Application No: BE/60/20/A
Site Address: Lidl Foodstore Land at Phase 1a Oldlands Farm Bognor Regis PO22 9NN
Description of works: Installation of various signage.

Thank you for your internet representation made on 5th August 2020 which has been recorded as no objection with the comments as follows:

Drawing Title:
PROPOSED FLAGPOLE

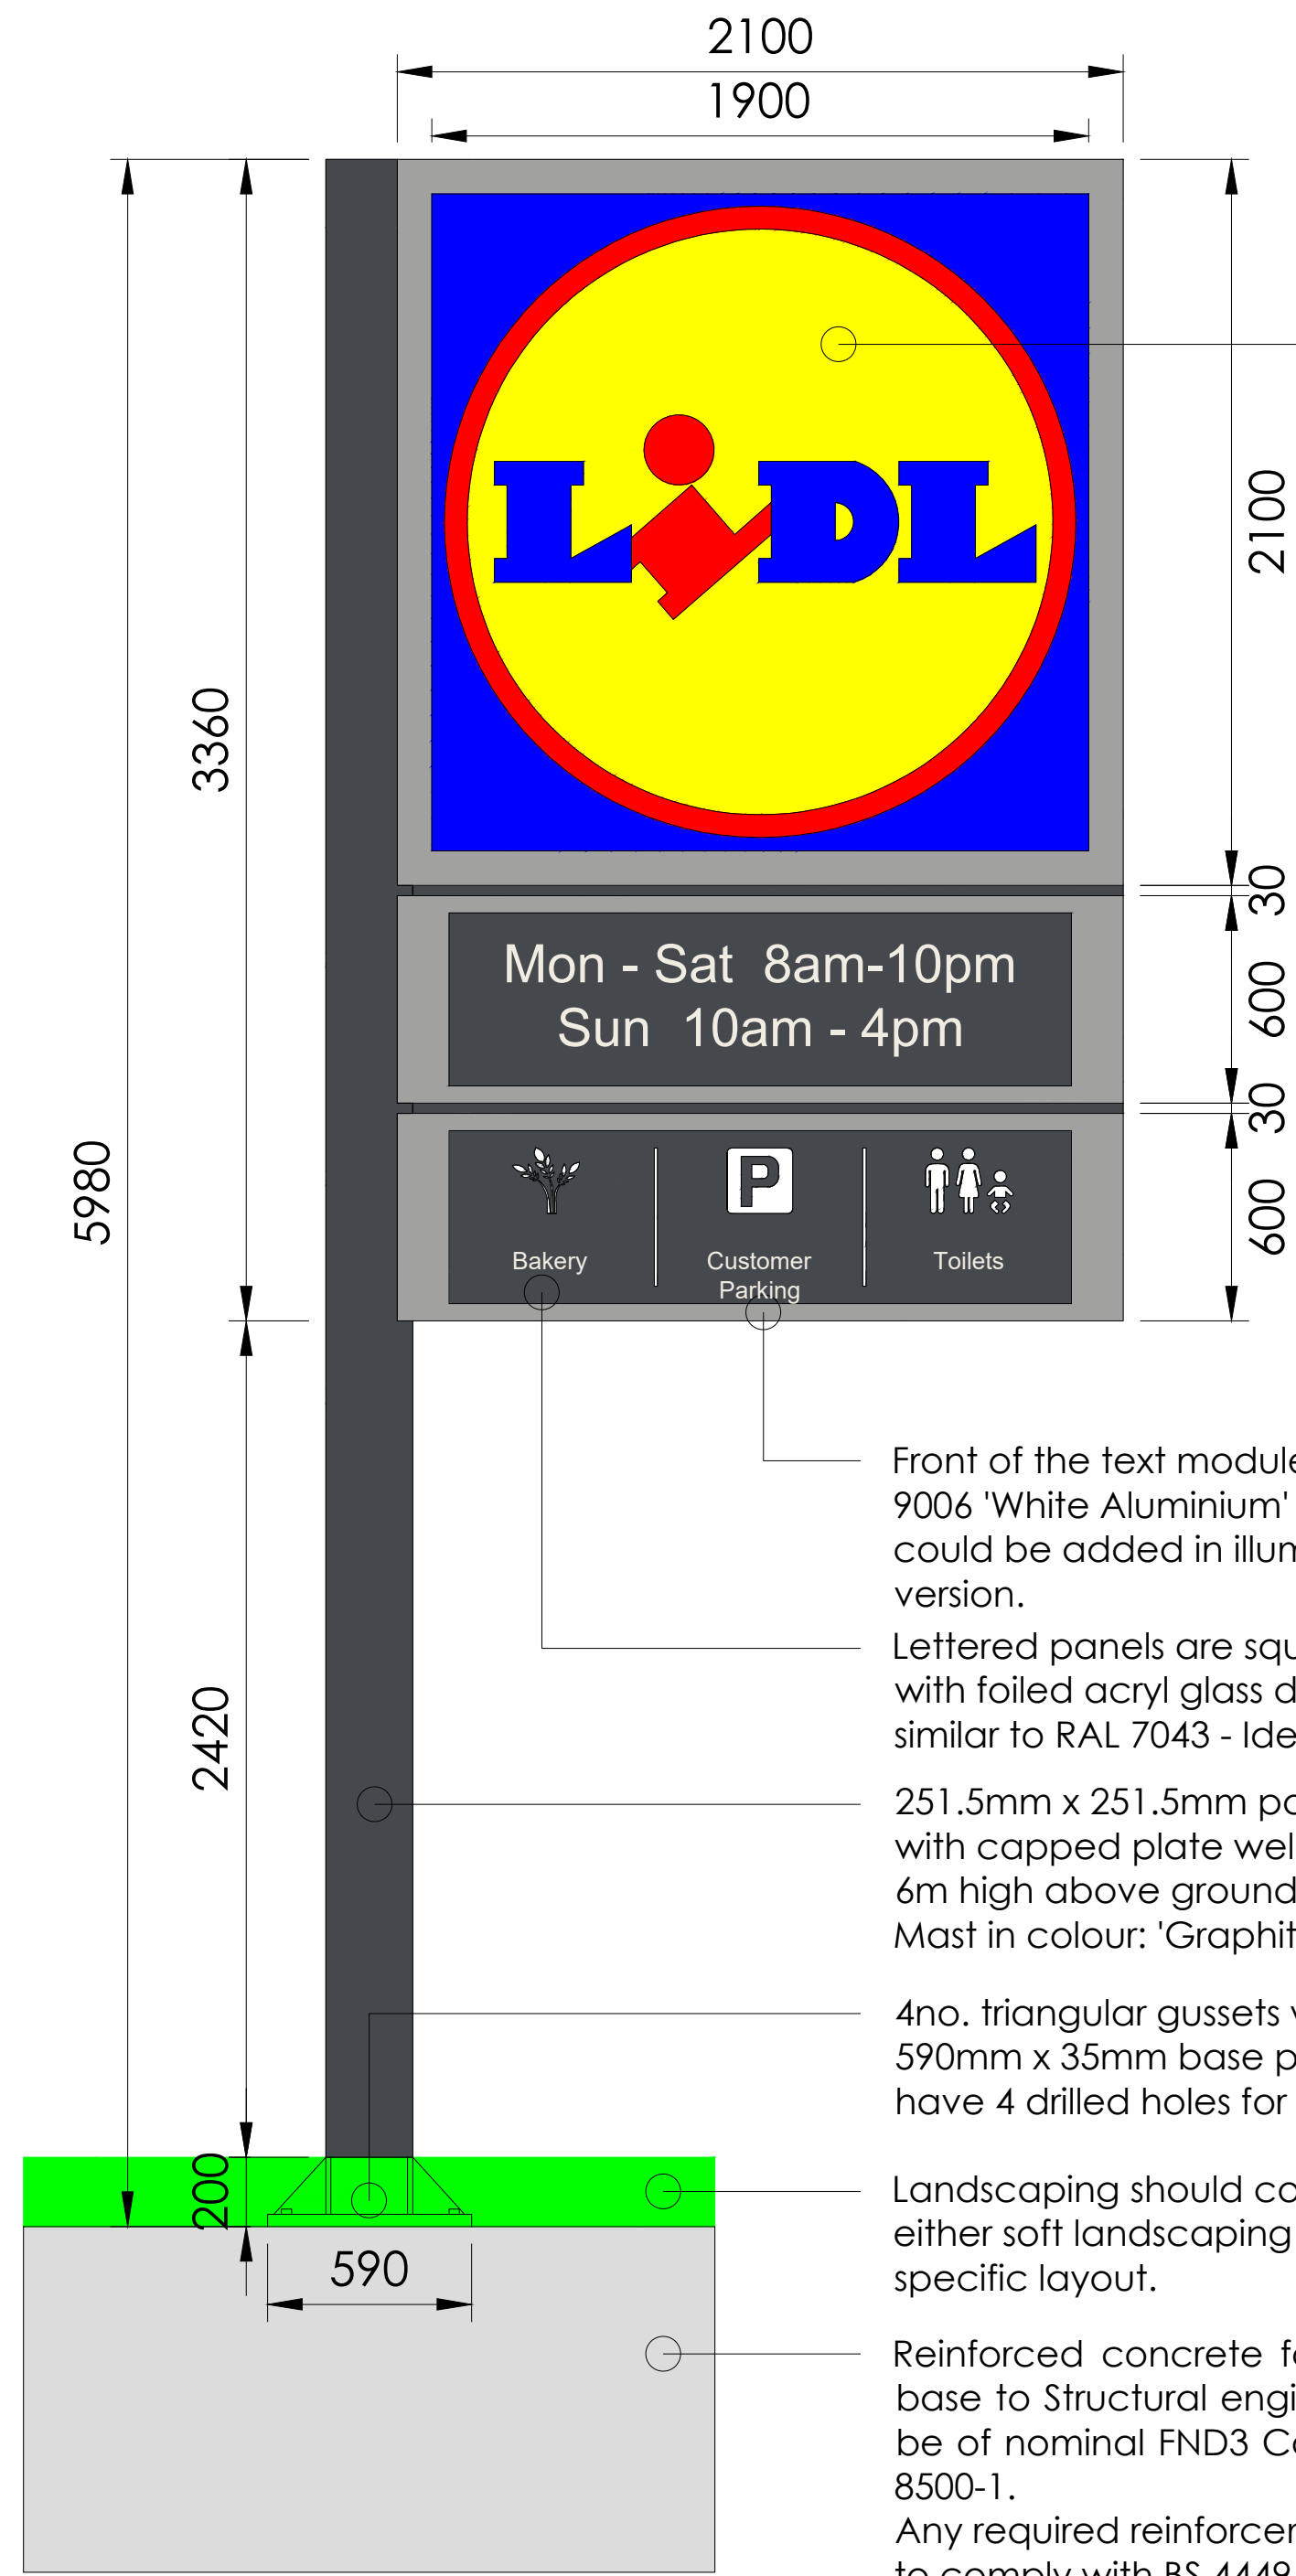
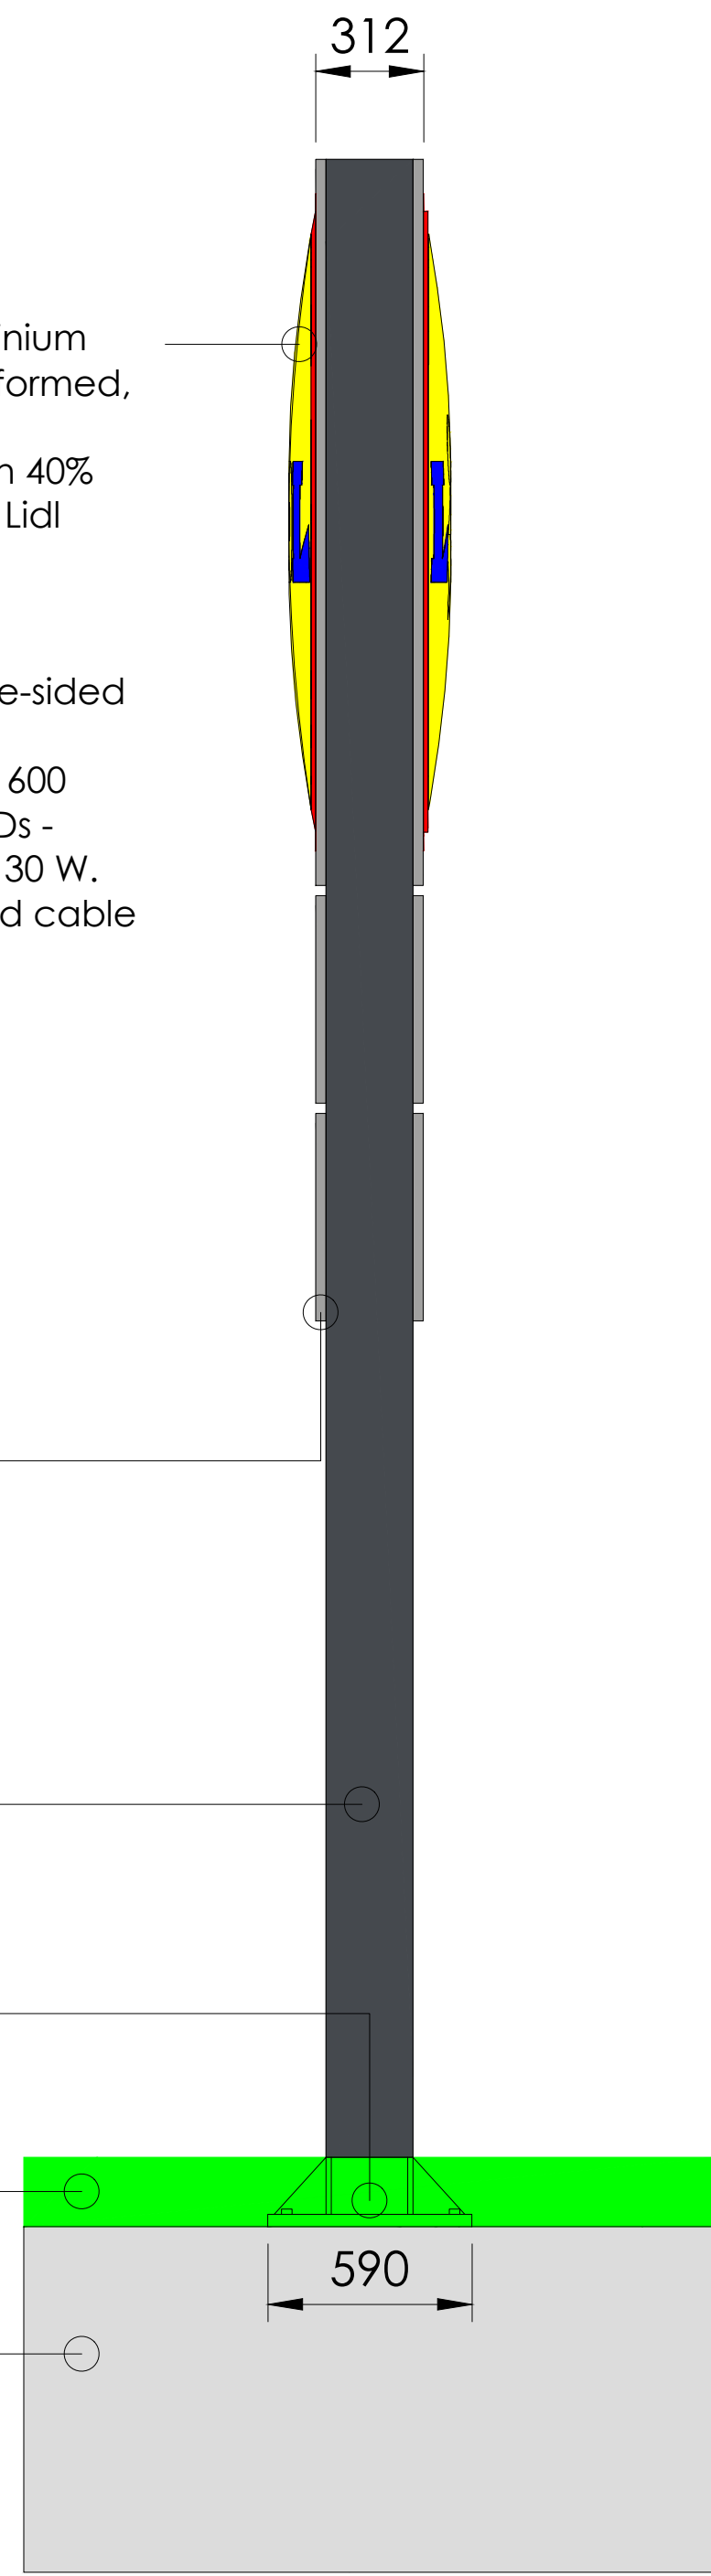
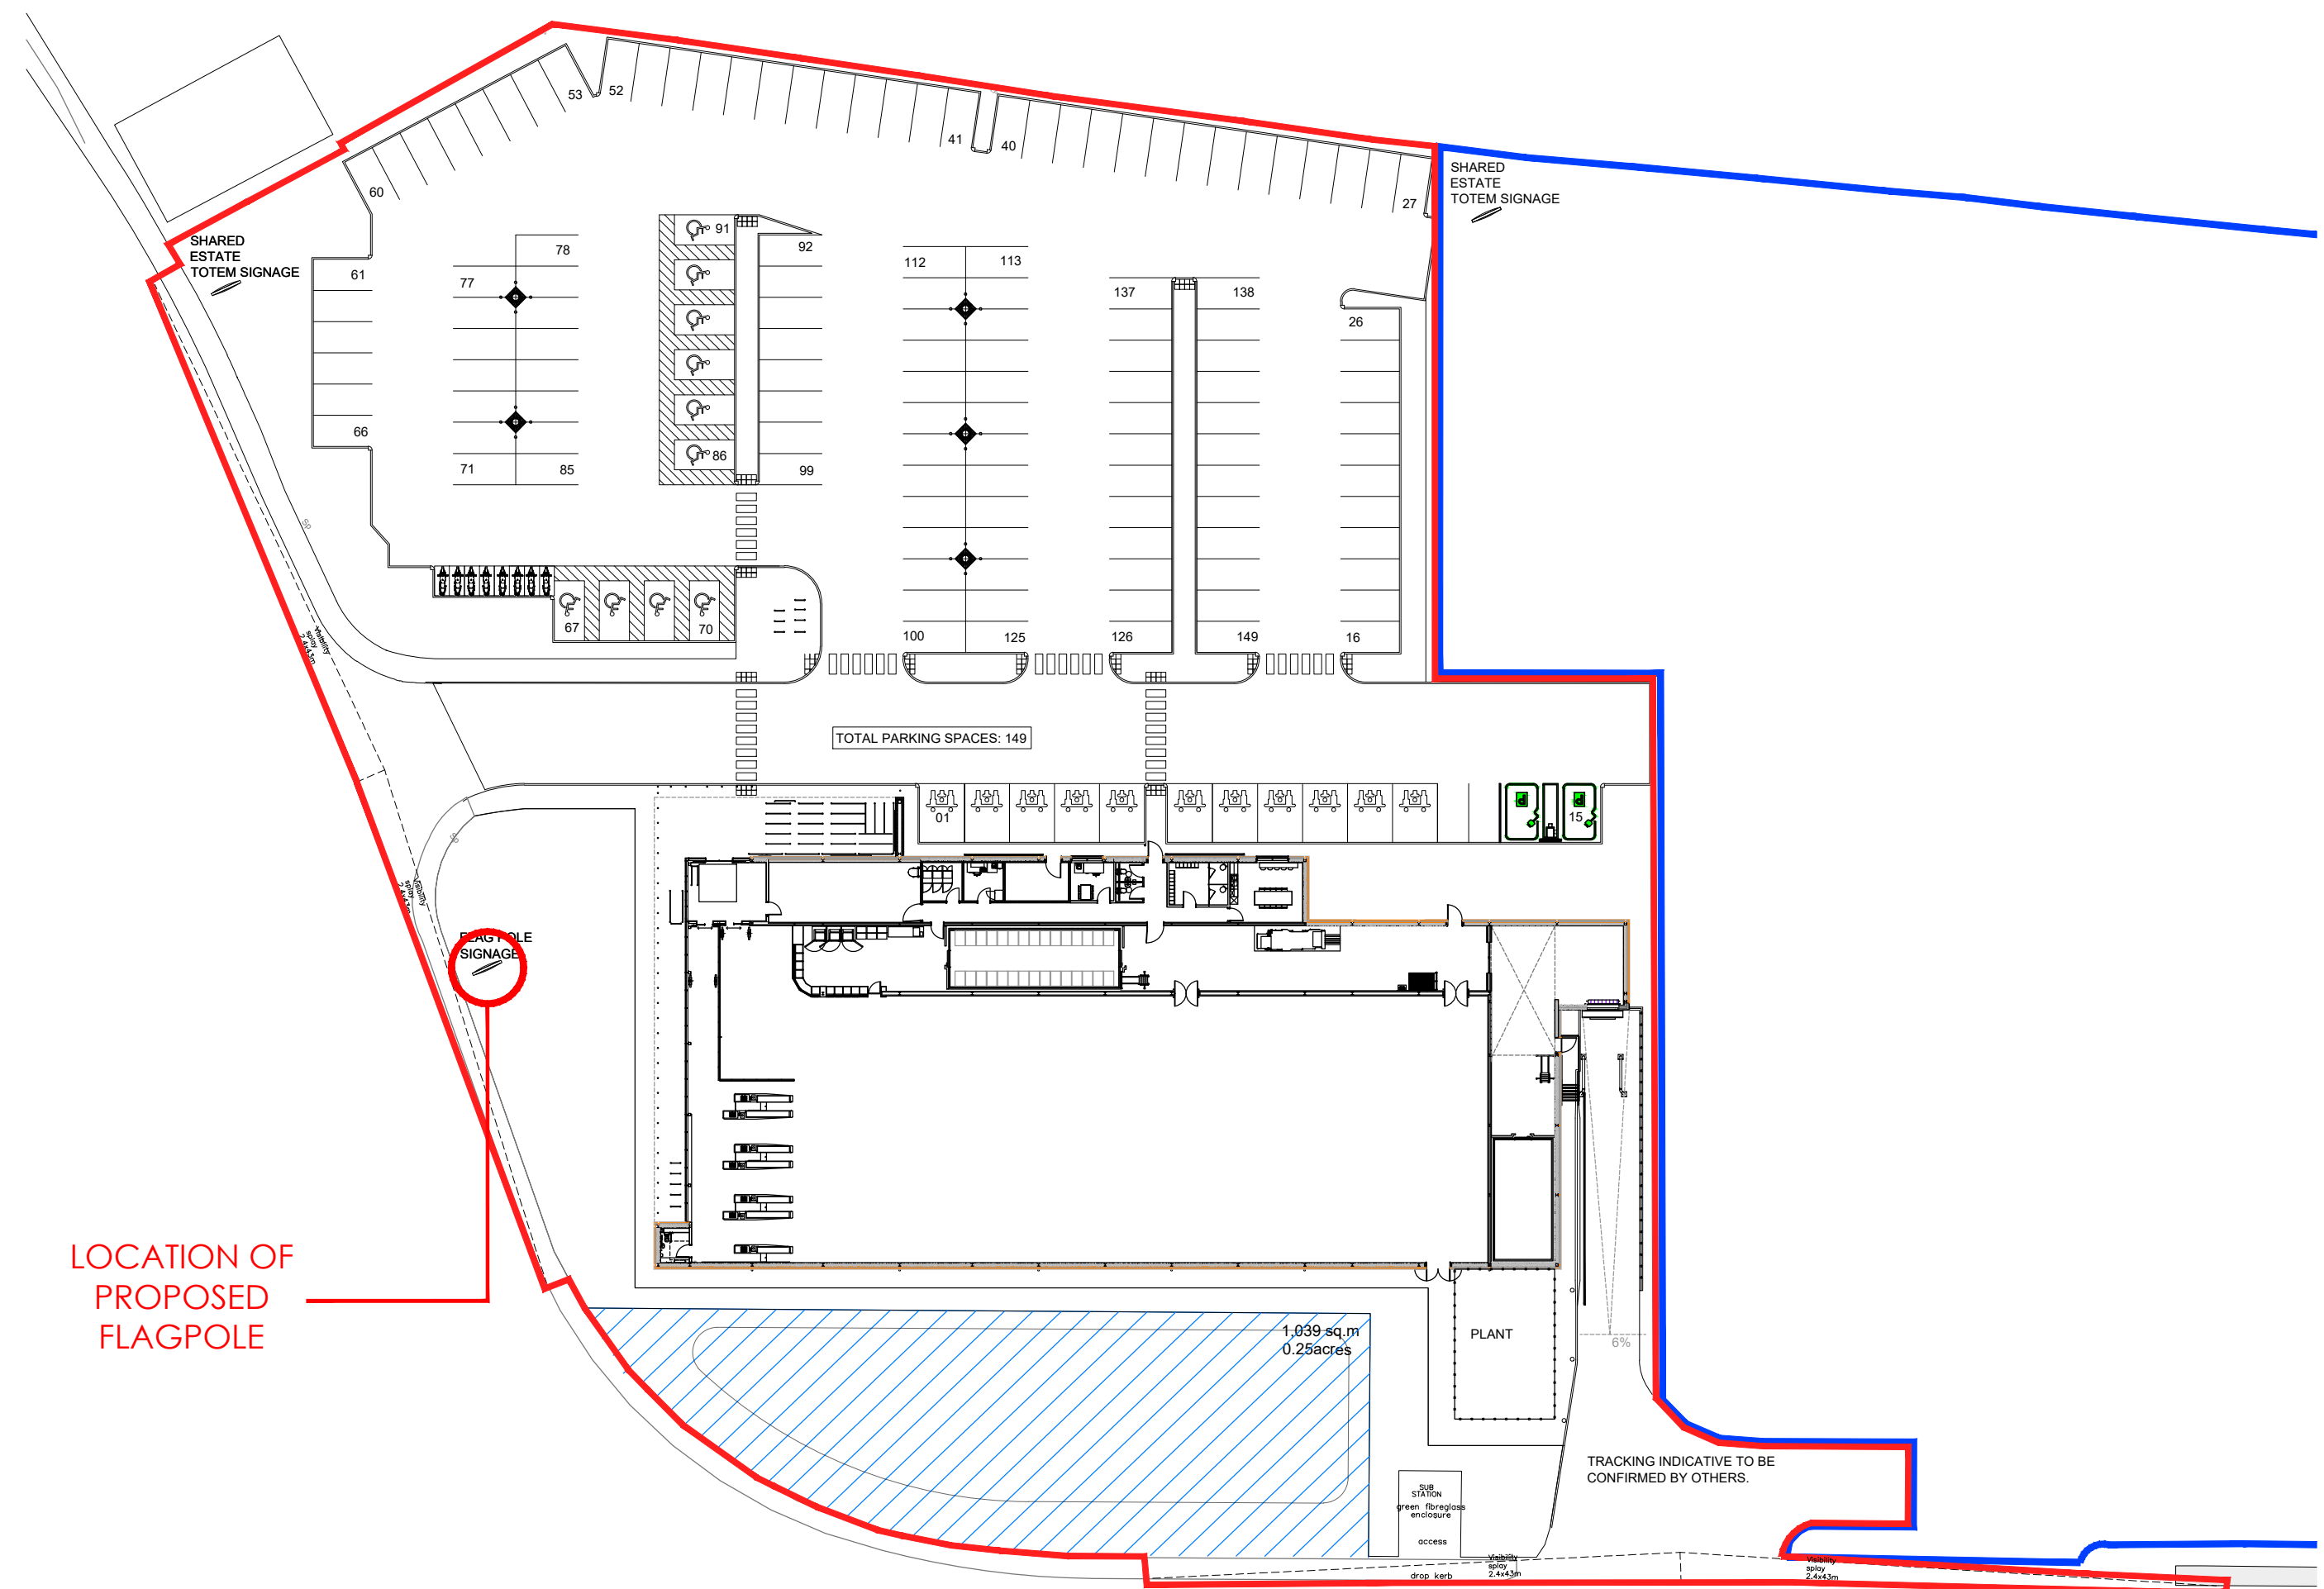
No Objection but would comment that the illumination of the totem signs does not impact on the residents of Shripney
